REAL ESTATE ASSESSMENT RECORD - CITY OF PORTLAND, MAINE

Permit No: 05-1006	Issue Date: NOV 3 2005	CE#: 040 AC24001
-----------------------	---------------------------	------------------

Proposed Project Description:
 build 14' dormer on 3rd floor of a three unit apartment building
15' shown on drawings

15'

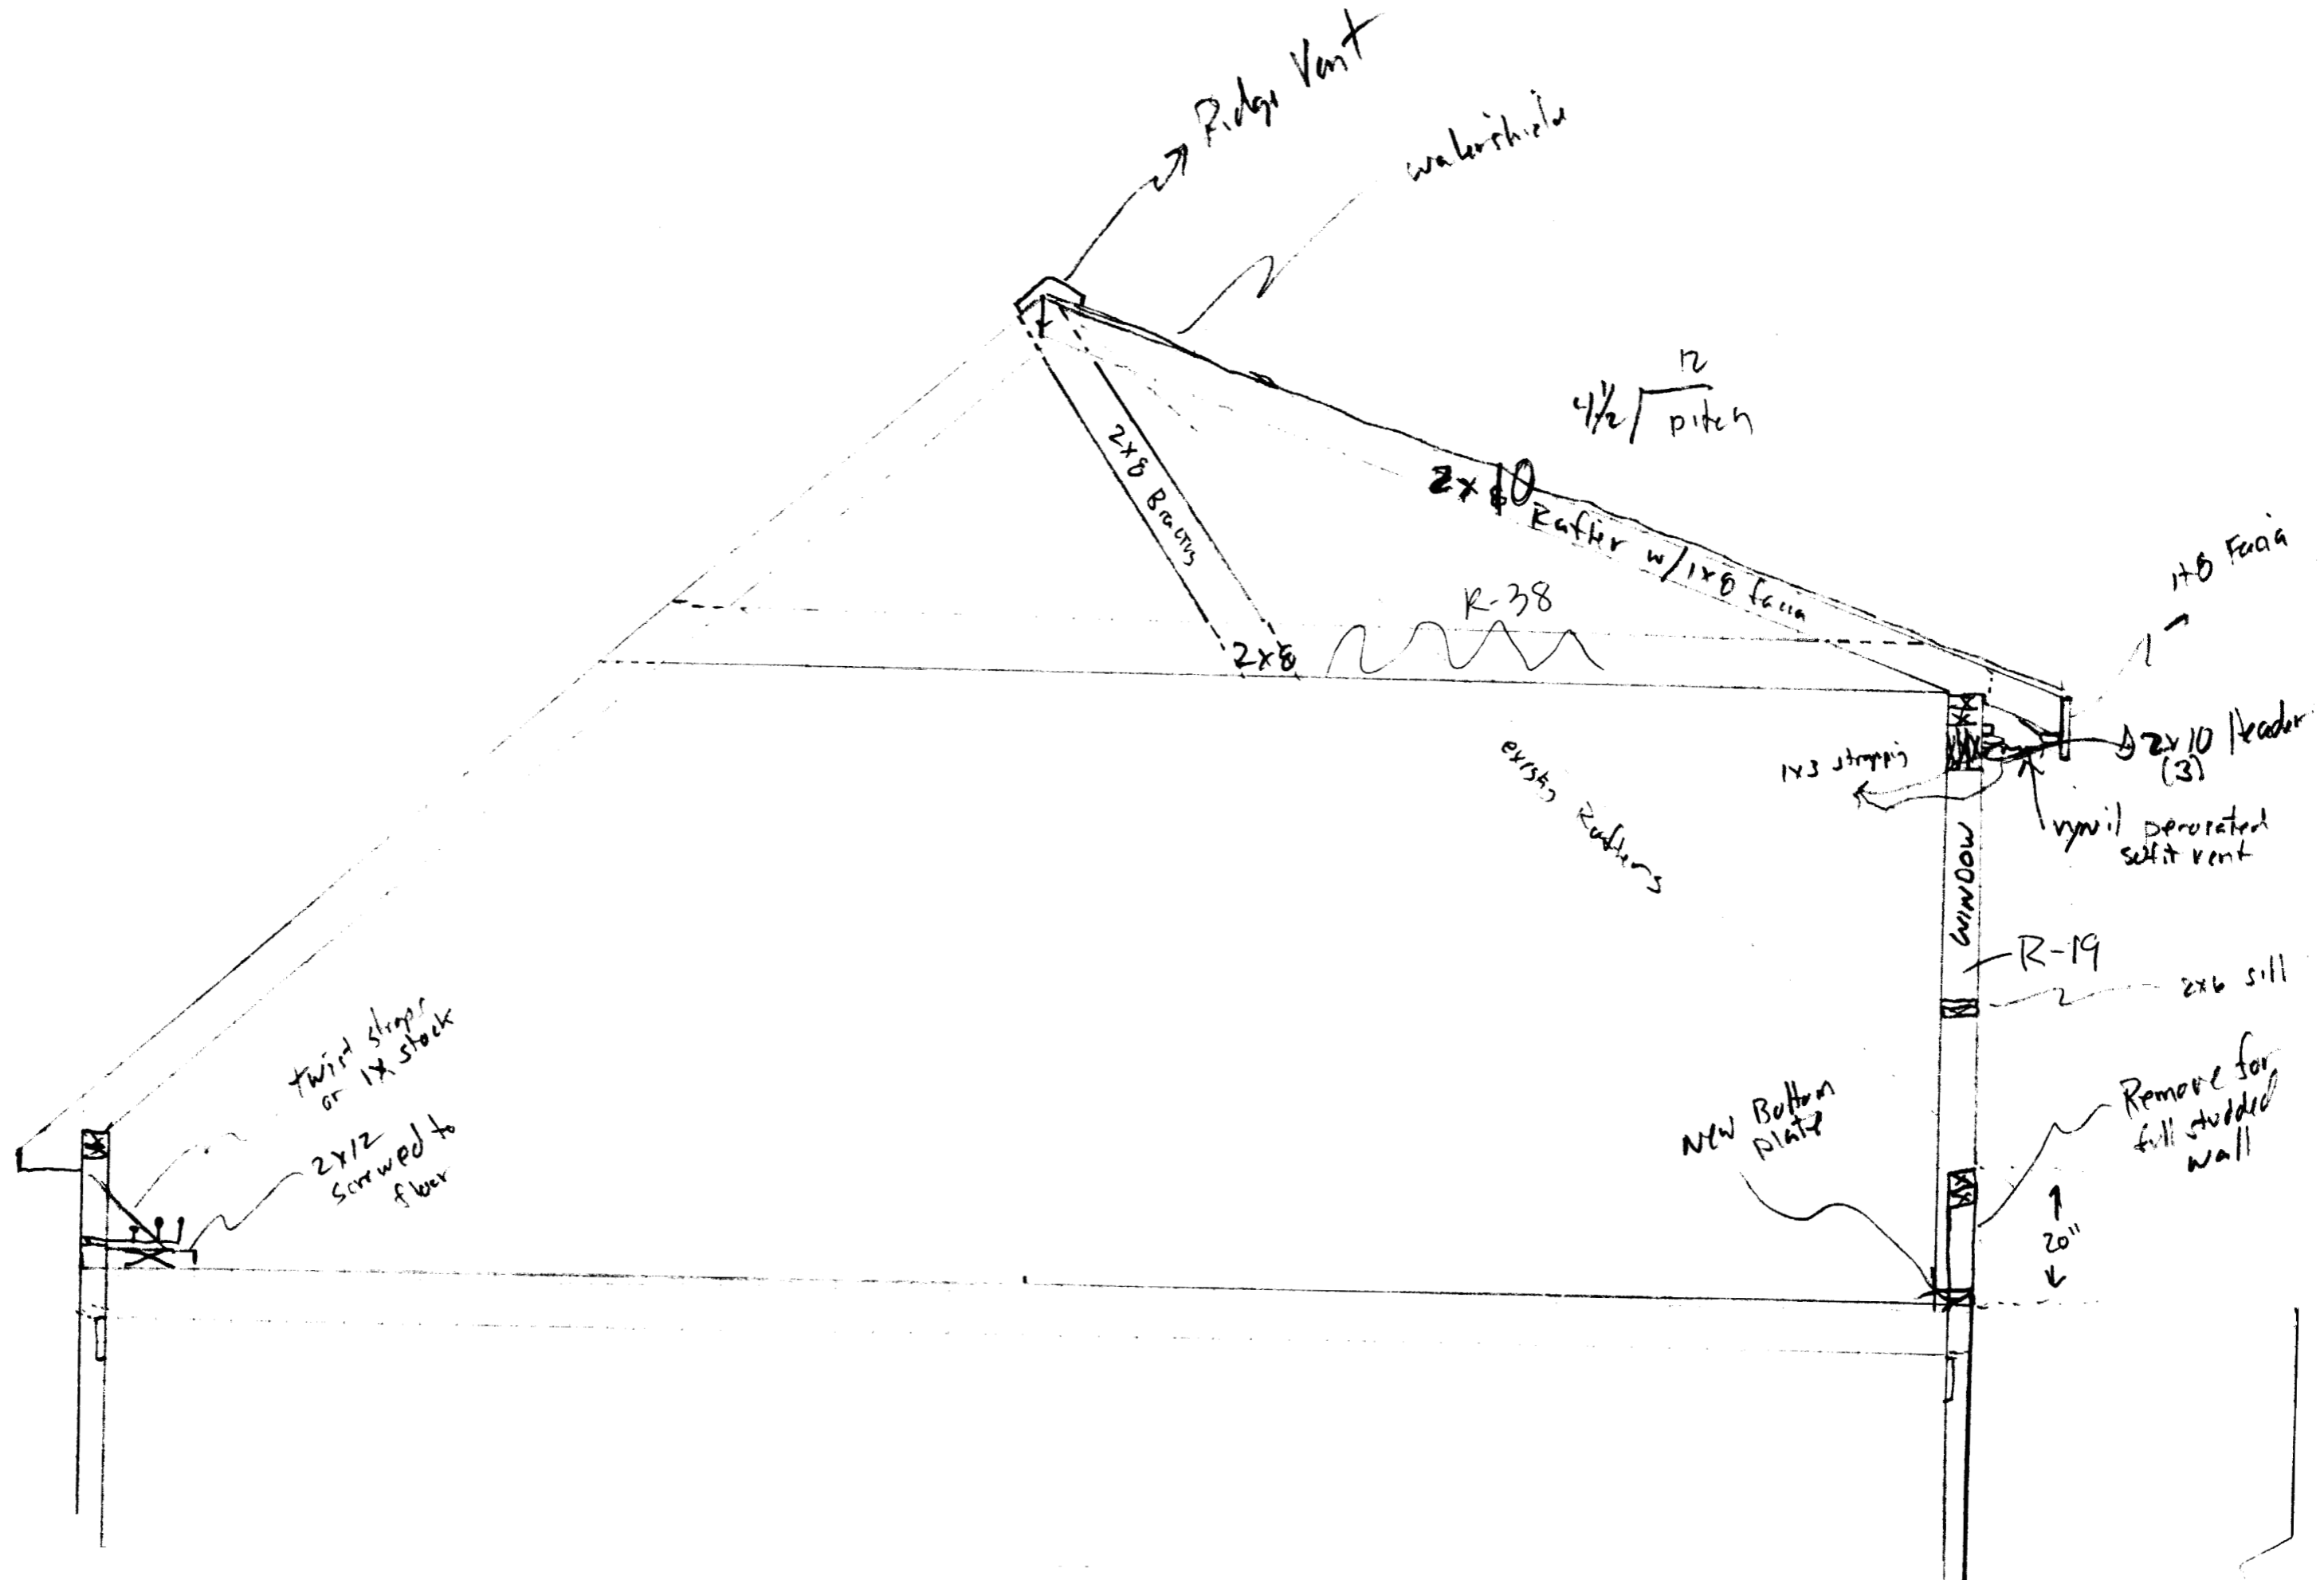
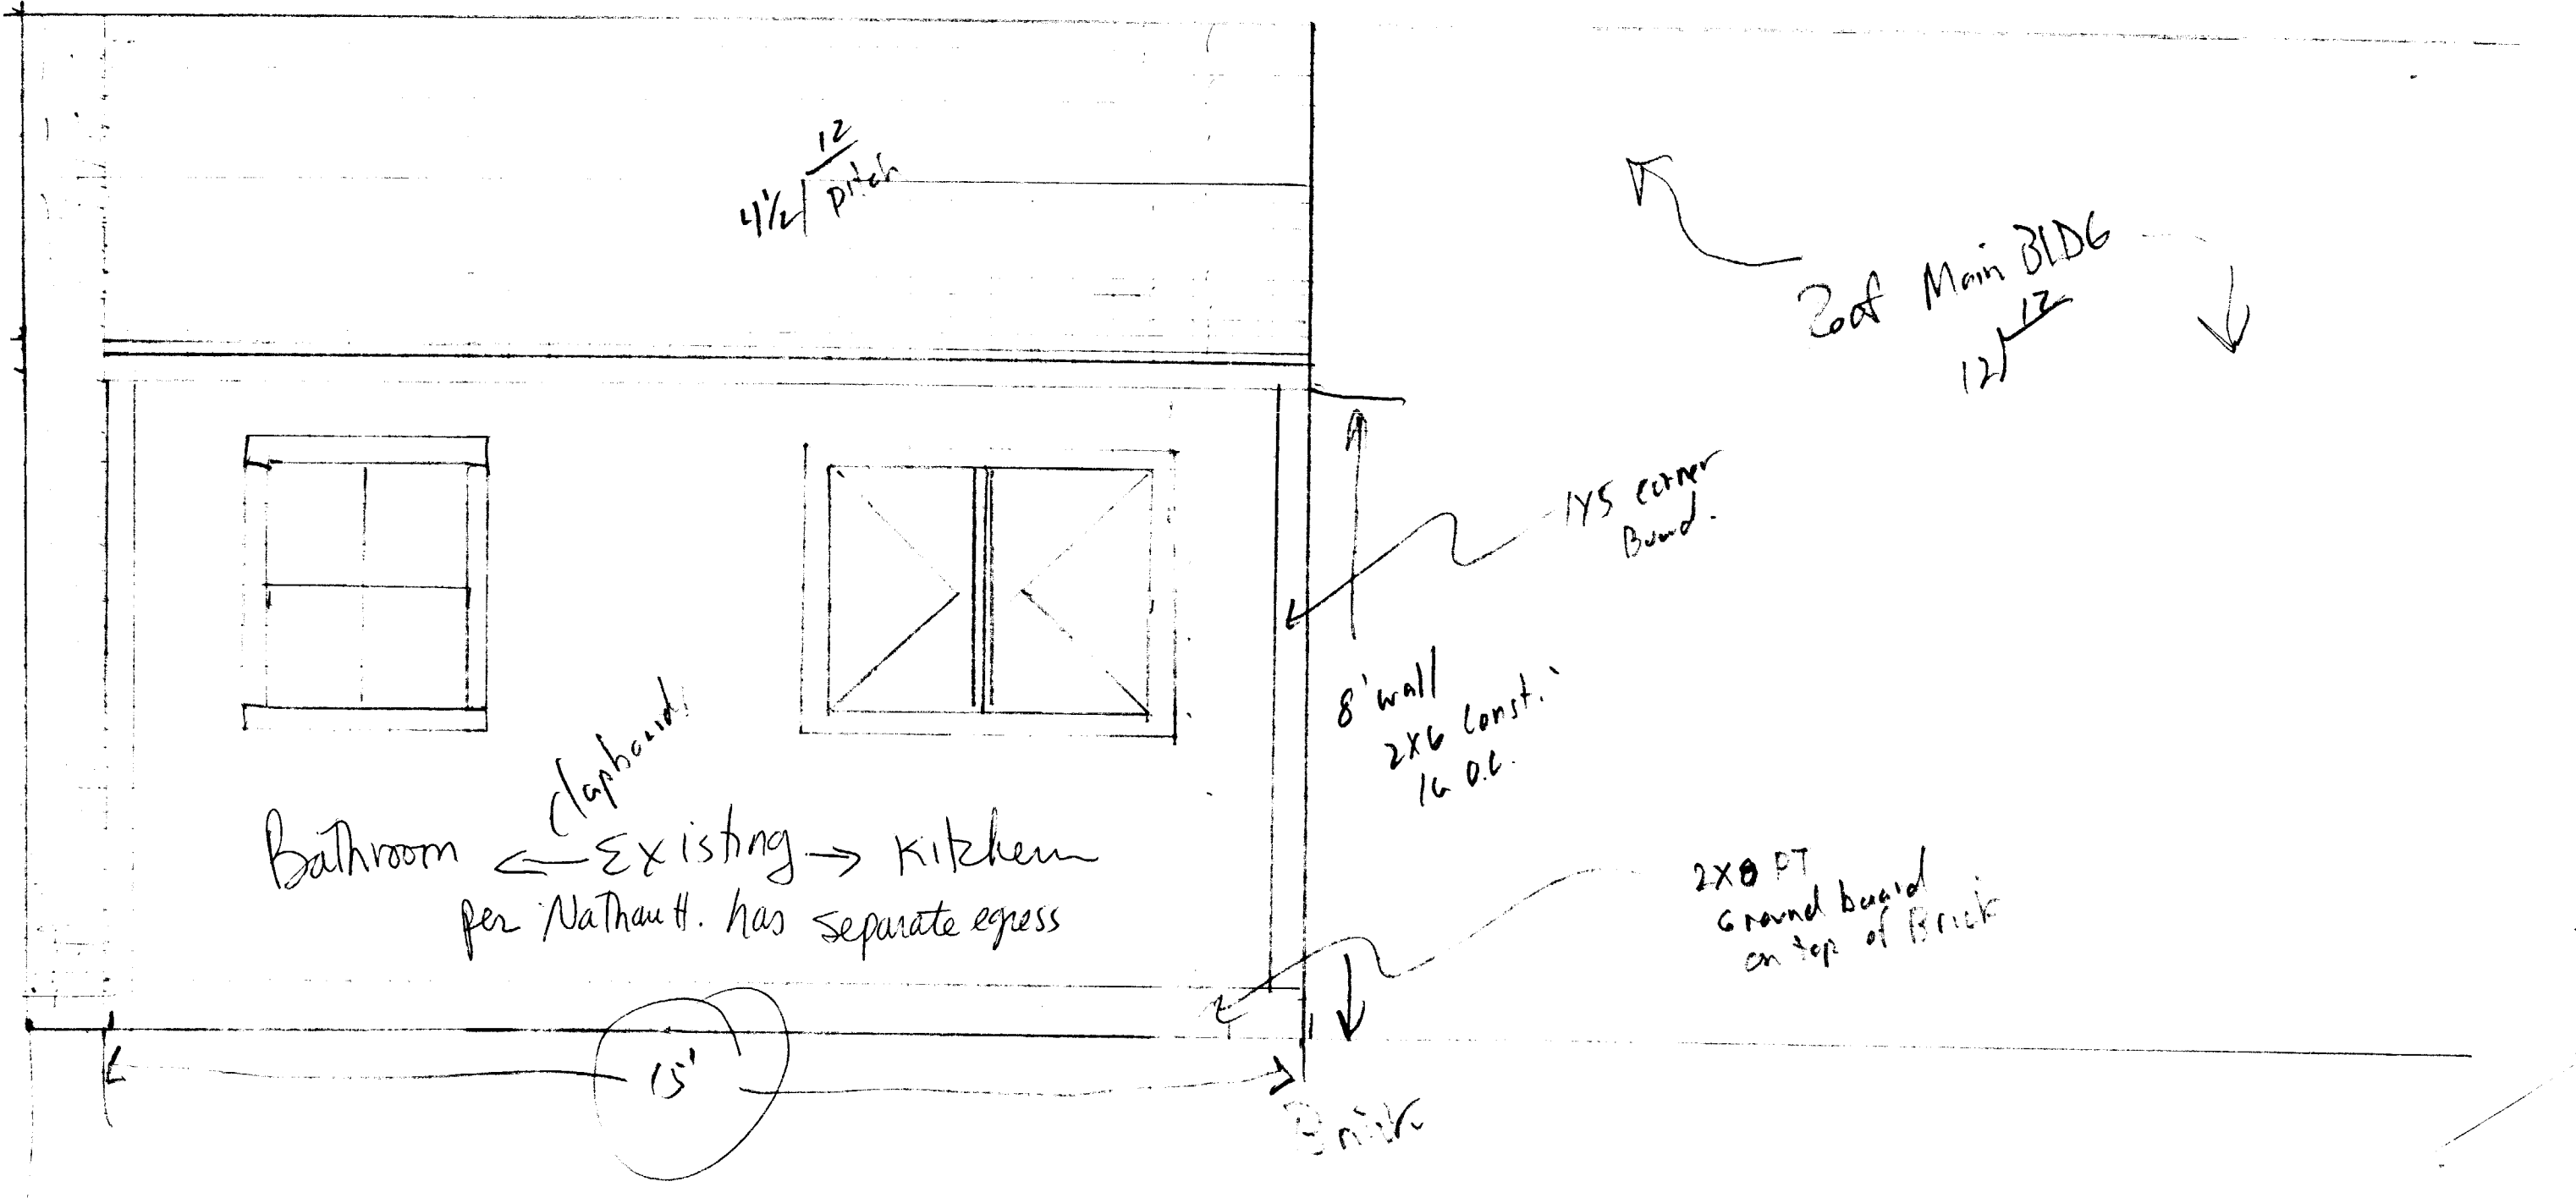
- 1) All building construction to comply with Nfpa 101
Insure two rated means of egress.

10/31/2005-mjn: Left message w/ Builder regarding current configuration of the space, egress etc.

11/02/2005-jmb: Spoke w/Nathan H. About existing use & egress; kitchen/bath in a sloped ceiling. Will change rafters to 2x10, insulation per code. No tub/shower on window wall. Ok to issue
